PLANNING CONSULTATION RESPONSE

Application No	2026/0503
Proposal	Erection of single storey office building (Use Class E(g)) with ancillary attached garage/store, external storage/open storage yard, formation of parking area and erection of wall/boundary treatments.
Address	Plot 9 Unit 1, Claycliffe Road, Barugh, Barnsley, S75 1HS
Date of Consultation Reply	16 th July 2026
Consultee	Highways DC

SITE PLAN
SCALE 1:200

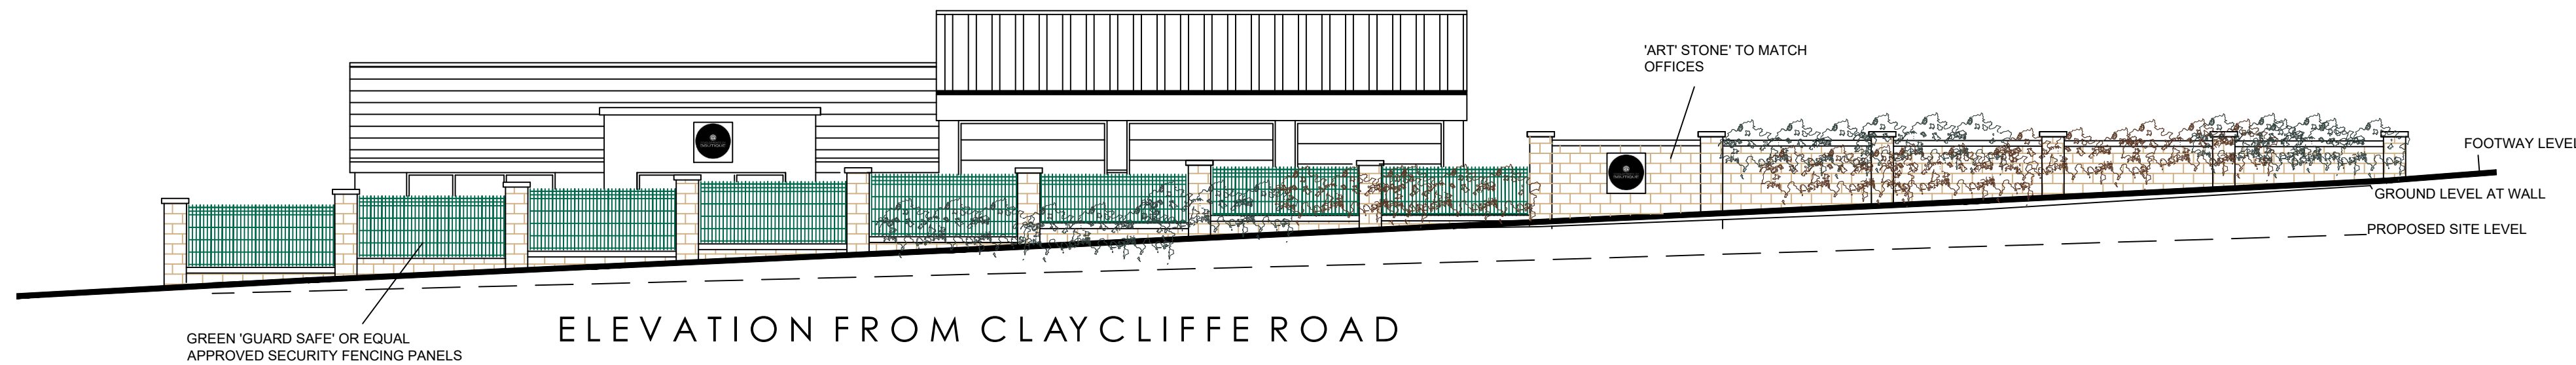
The proposed redevelopment of the existing car sales/garage site proposes to use the existing access point, albeit with an amended layout. The proposed access arrangement would include a slightly realigned entrance and a wider gated access point; the alterations are acceptable from a highways point of view.

The site boundary along Claycliffe Road would also be altered from its current position so that it runs parallel with the public highway. The boundary would be set back into the site so as not to impede visibility; it would appear that a 4.5m x 120m sight line is still achievable with the site boundary alterations.

The proposed Class E(g) office use would provide 133m² of floorspace; reference to the Barnsley Supplementary Planning Document (SPD) Parking (2019) Table 1 shows that 1 parking space should be provided per 30m² of floorspace which equates to a requirement for 4 spaces to be provided within the site. The submitted site layout plan shows that 4 spaces of sufficient dimensions are to be provided within the site, thereby satisfying the parking requirement.

Although the car parking arrangements are satisfactory, no information has been provided with regard to the operation of the site and whether vehicles other than cars would use the site, and, if so, the frequency that they would visit. Information should therefore be provided which details the general operation of the site on a typical day in terms of vehicle movements along with the size and type of vehicles. Details of the largest vehicle that would visit the site should be provided and it should be demonstrated that such vehicles are able to carry out a turning manoeuvre within the site.
